# CITY OF ALBUQUERQUE

October 1, 2018

**Re: La Pasada Kitchen Addition**  
**2206 Fourth st. NW ALB 87102**  
**Traffic Circulation Layout**  
Engineer's/Architect's Stamp 08-13-18 (H14D089)

MARK	DATE	DESCRIPTION
ISSUE:		100% CDs
DATE:		SEPTEMBER 24, 2018
PROJECT NO:		704
CAD DWG FILE:		
DRAWN BY:		RH
CHECKED BY:		BEB
SHEET TITLE		
TCL - SITE PLAN

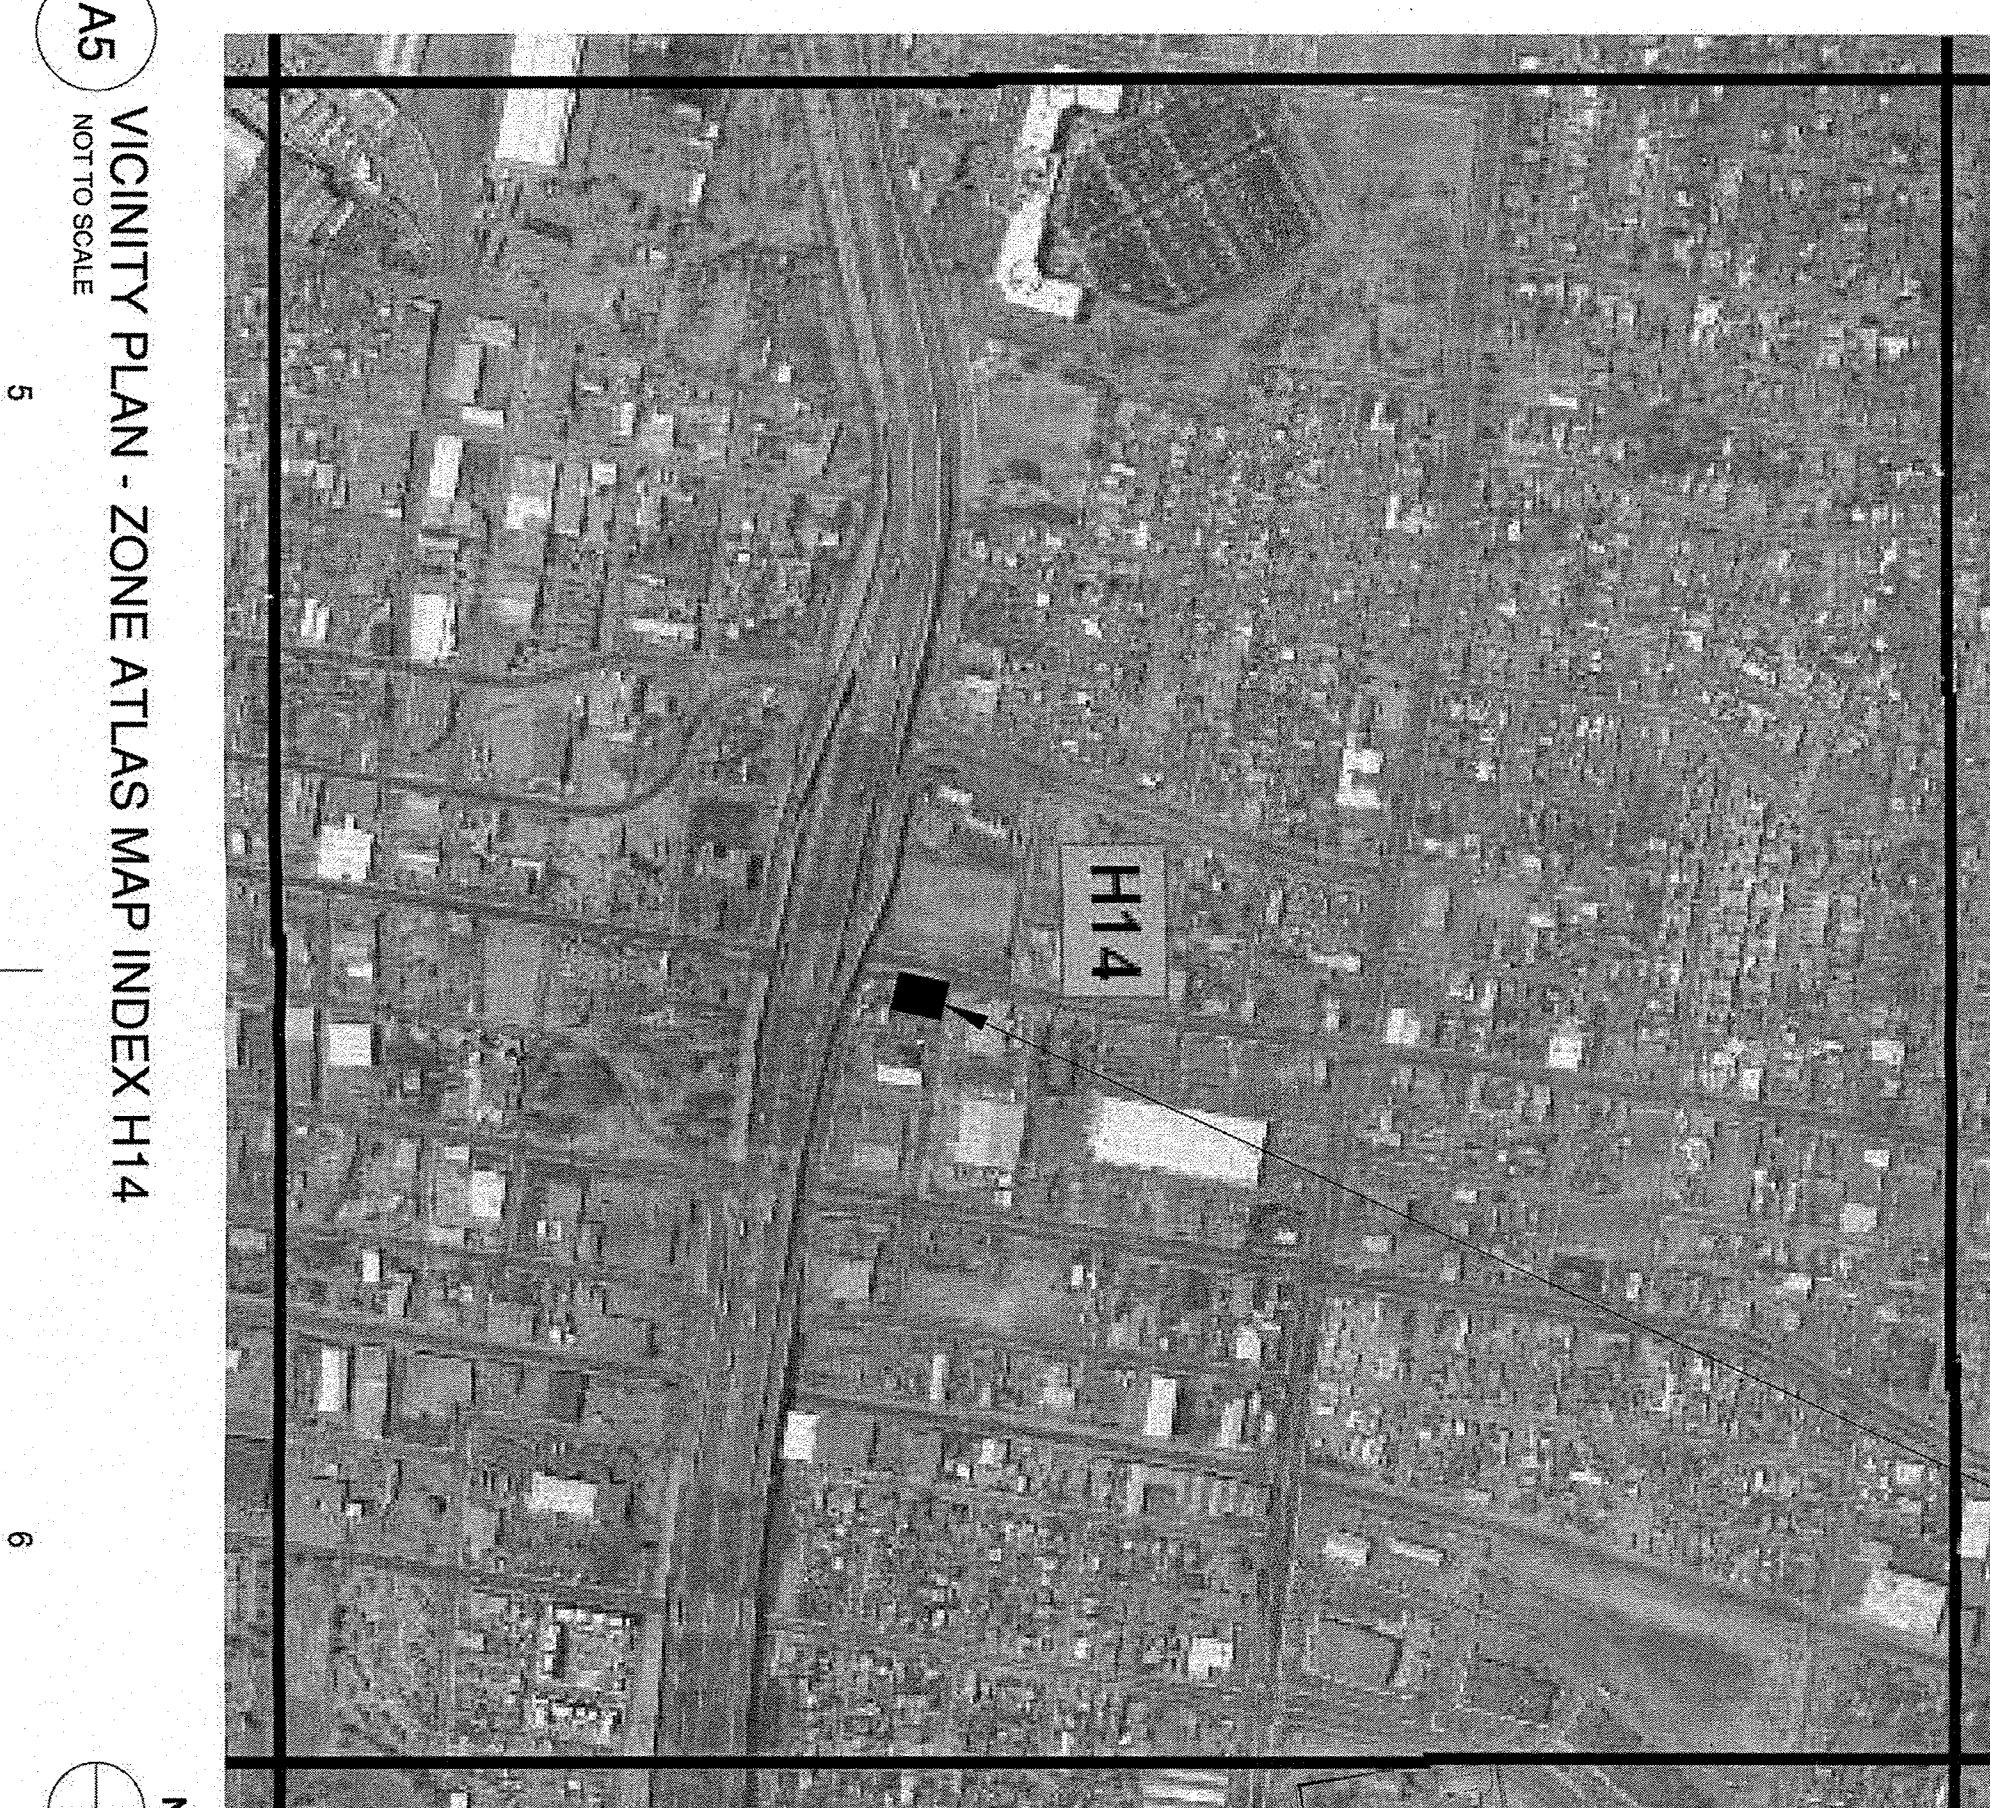
The TCL submittal received 09-27-18 is approved for Building Permit with the condition of adding "NO PARKING" on blue striping next to ADA access, which will be checked for certificate of occupancy. A copy of the stamped and signed plan will be needed for each of the building permit plans. Please keep the original to be used for certification of the site for final C.O. for Transportation.
